**Consultation Response from KC,
Highways Development Management****2024/92283 Dewsbury Market, 32 Cloth Hall Street, Dewsbury, WF13 1QE****Redevelopment of market with addition of mezzanine floor****Date Responded: 27/11/2024****Responding Officer: CNB****Responding Ref: K15-2NE/27**

This application is for the redevelopment of the Dewsbury indoor and outdoor market to enhance the market offer, improve waste storage, and create an event space and park area.

Small Van Tracking (Market Setup)

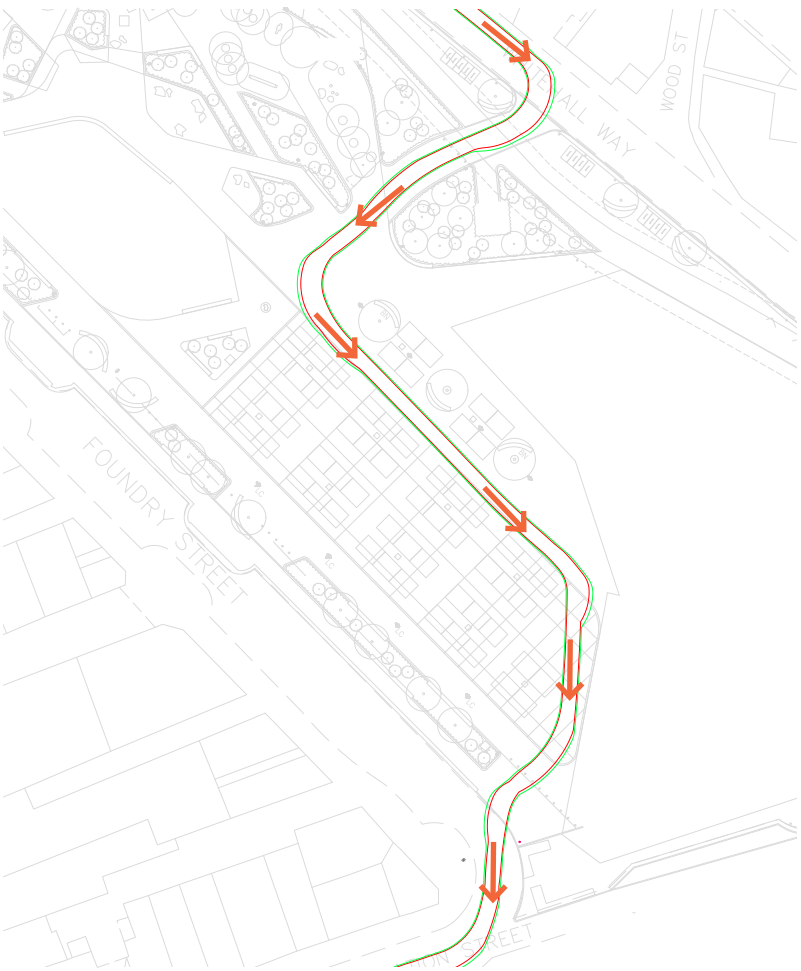
Drawing 950001 shows that a 5.8m long wheelbase Transit style van can access the site for deliveries and loading purposes for the stallholders and this would be expected to be the largest frequent visitor to the site. The proposed route into the site is from an access part way along Whitehall Way with the exit being on to Foundry Street/Corporation Street. This proposed route is acceptable, however we would need to see details of how access by larger vehicles would be restricted along this route and this should be included within an Access Management Plan for the site.

Large Fire Tender Vehicle

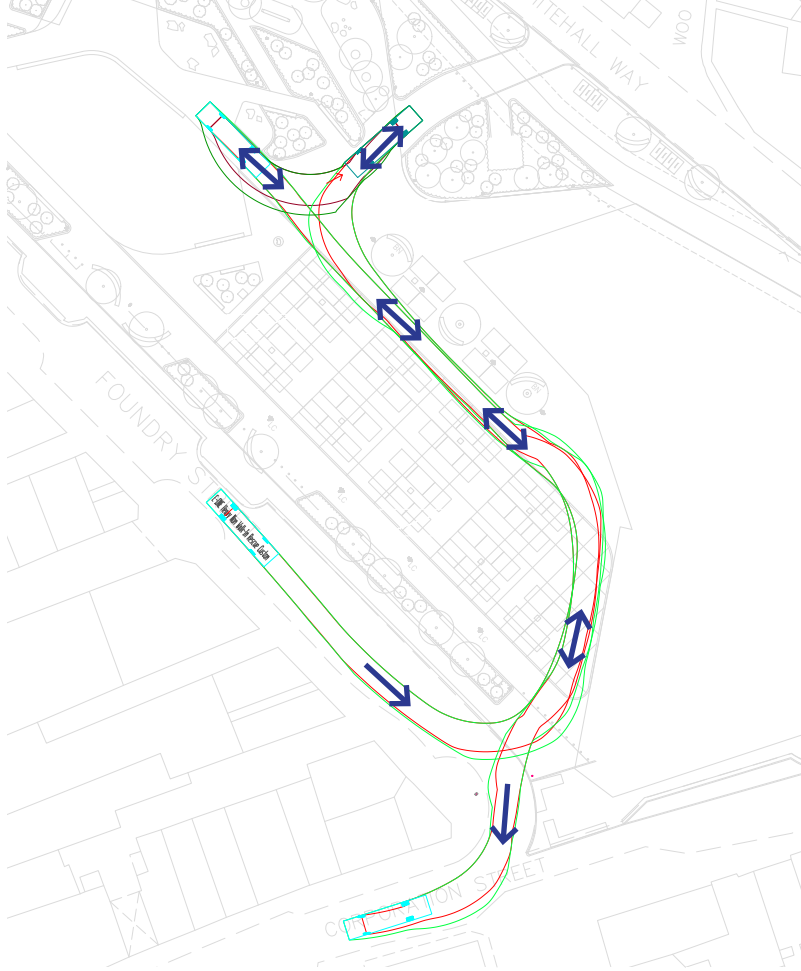
Drawing 950002 shows a swept path analysis for an 11m fire tender with access and egress taking place from Foundry Street. The swept path shows the route through the site to be very tight and at two locations it indicates that there would be a clash between the vehicle and market stalls, this wouldn't be acceptable, and we would wish to see the market stalls relocated to ensure that a fire and rescue service vehicle can safely access and egress the site. Narrow clearances and collision points would slow the access of the vehicle in the event of an emergency.

Notwithstanding the details shown on the approved plan, the development shall not be brought in to use until a scheme detailing arrangements and specification for safe and easy vehicular access for an approved emergency services Fire and Rescue vehicle, consisting of a swept path analysis, has been submitted to and approved in writing by the Local Planning Authority.

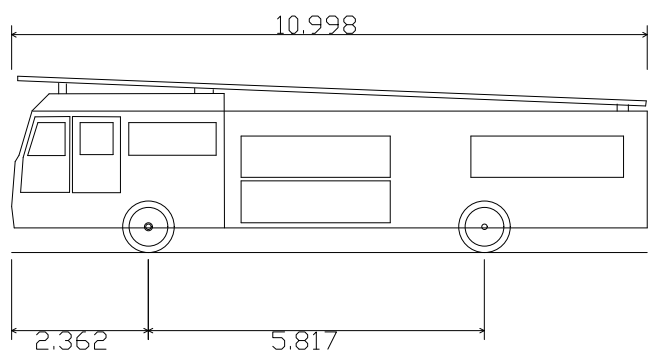
The access for a light goods vehicle and an articulated goods vehicle are acceptable, however the emergency services vehicle access is unacceptable and this concern should be addressed before we would be able to support the application.

With this we cannot currently support the application due to highway safety concerns relating to the access route for a fire appliance.
